COUNTY COUNCIL'S RESPONSE TO CONSULTATION ON THE FOLLOWING DEVELOPMENT PROPOSAL

Application No: 19/01740/HYBRID-3

Location: Land Adj To Promised Land Farm, Wendlebury Road, Chesterton

Response date: *9th April 2020*

CYCLE SHELTER DETAIL

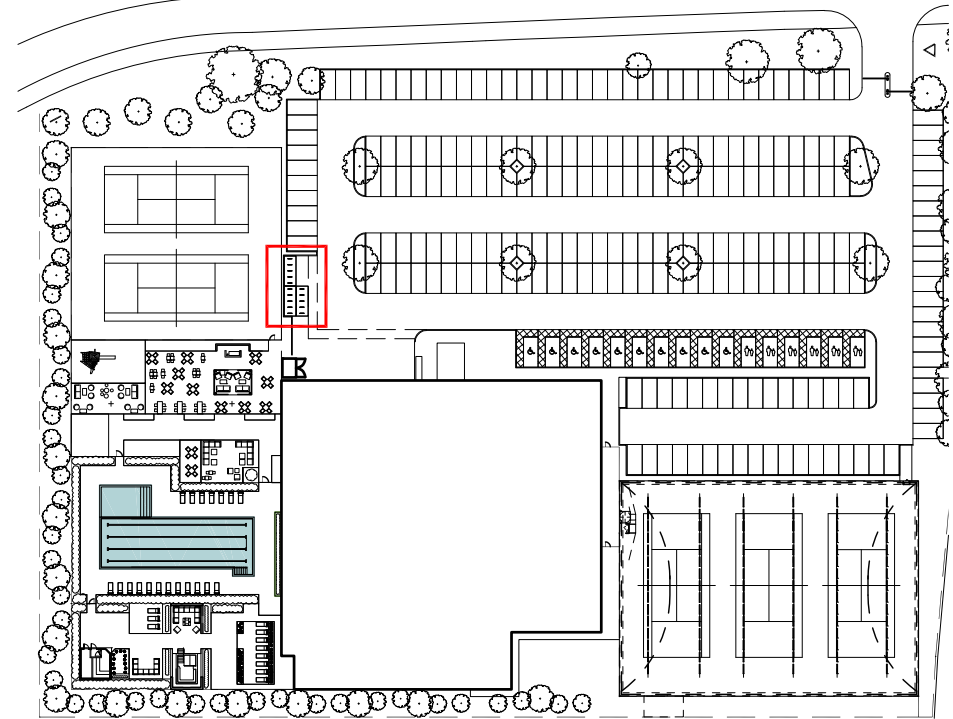
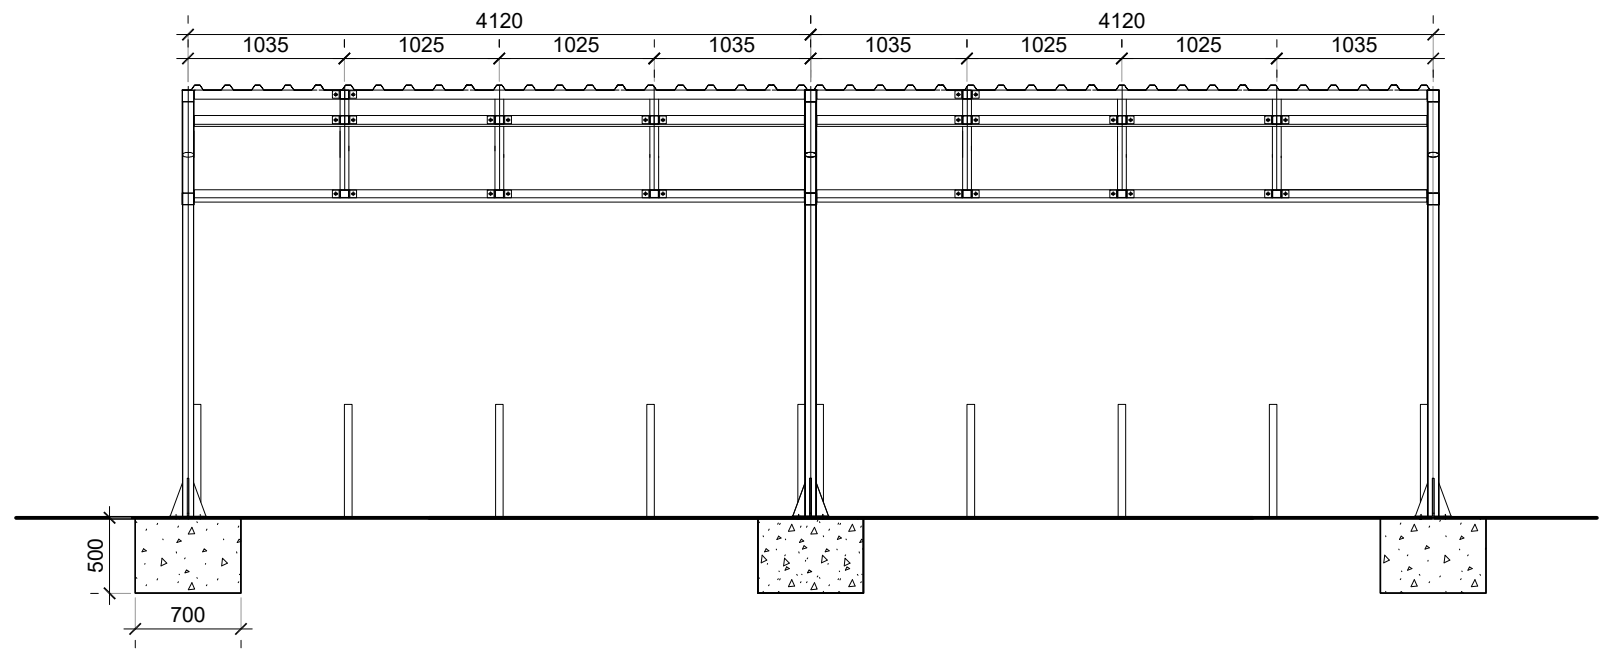
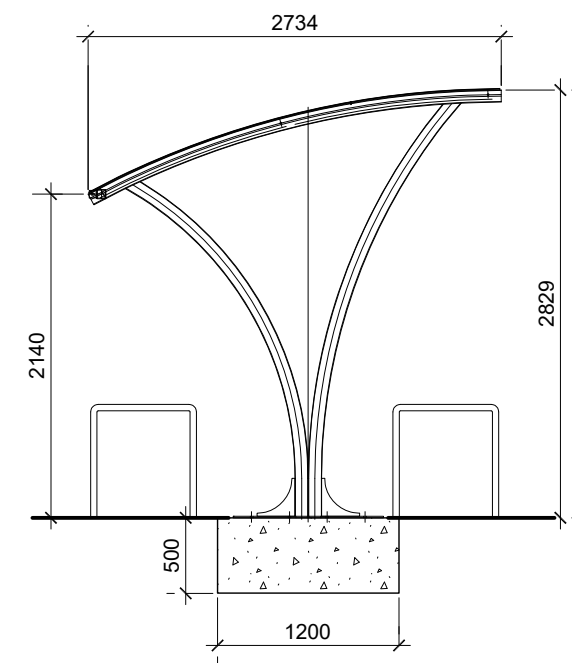
Cycle Parking – Following discussions with DTA, it was agreed to make an increased provision to a 30-cycle parking facility which shall be under cover in a suitable location. This has now been illustrated by Drwg No: *A-PL-09-010 Rev P05* which I wish to say addresses OCC previous concern on this issue.
